From: Louise Crane
Sent: 13 February 2017 09:54
To: Planning.Responses
Subject: FW: Planning Consultation on: FG/198/16/PL

APPLICATION FG/198/16/PL

Site Address: 1 Sea Drive Ferring BN12 5HD

Description of Works: Demolition of existing house with erection of 2 storey building comprising of 8No. residential 2 bedroom flats & associated external works

FIRST FLOOR PLAN

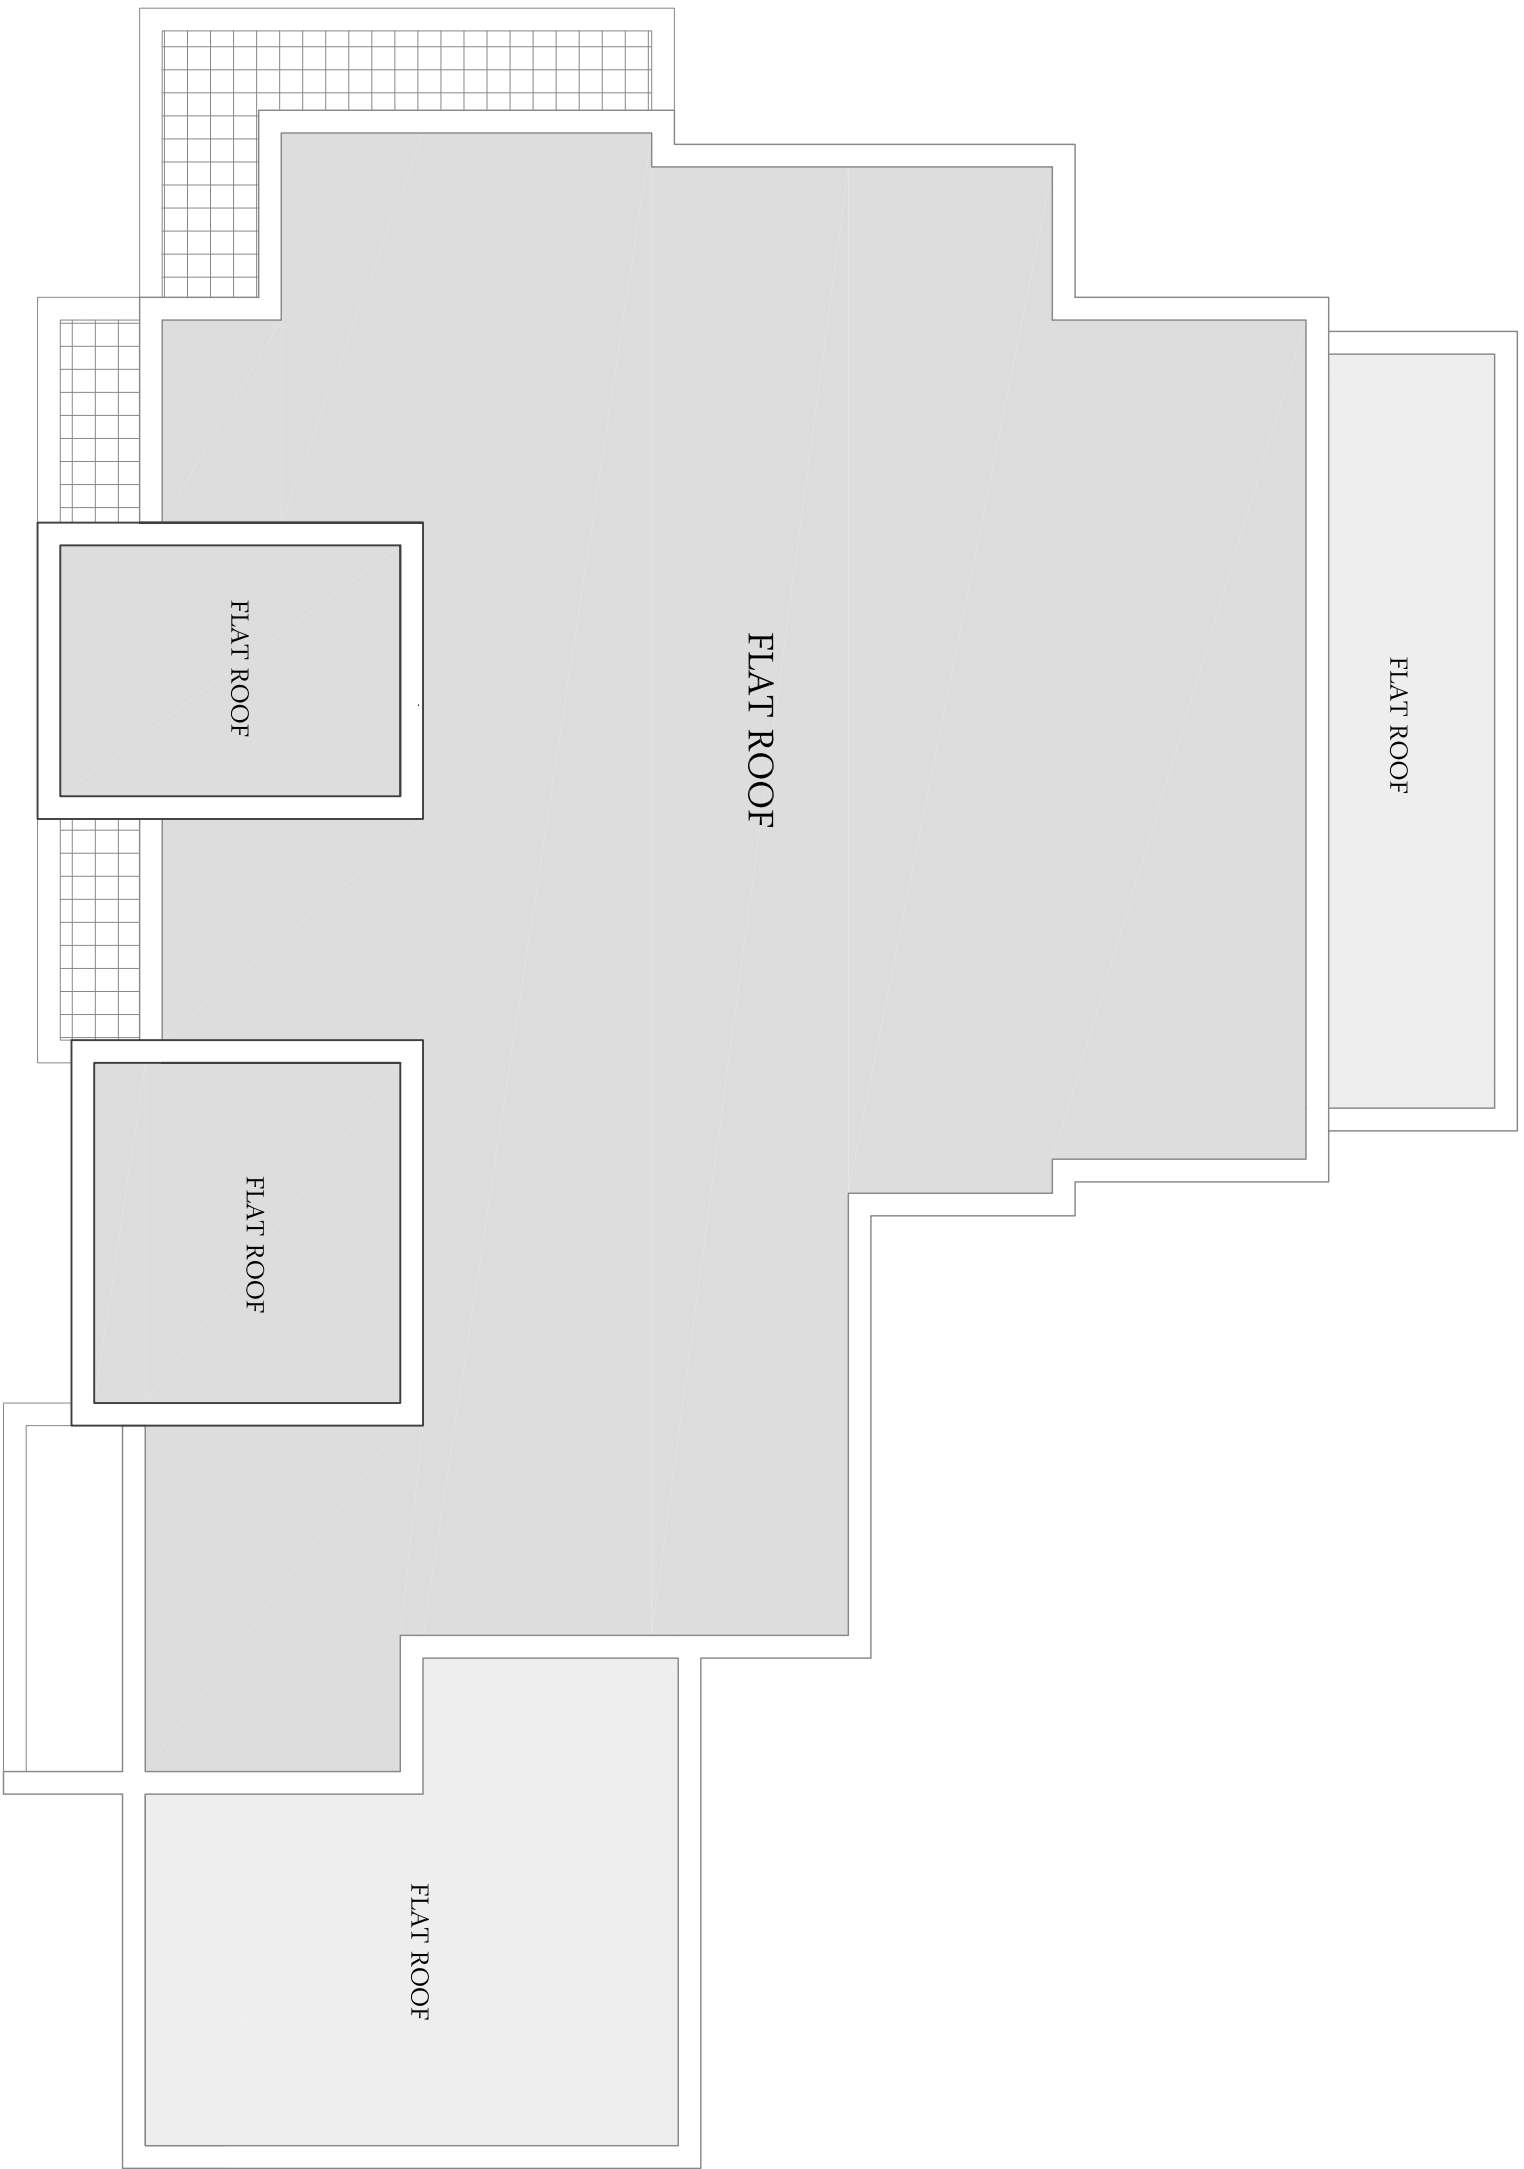
- Any bathrooms and kitchens without windows for natural ventilation should have adequate mechanical ventilation.

- Room sizes should meet the minimum standards for houses in multiple occupation if the flats are intended to be rented.

- The property would need to meet all fire detection and safety requirements as per the Lacors: Housing - Fire Safety: Guidance on fire safety provisions for certain types of existing housing, including adequate separation from any commercial units located below and external means of escape;
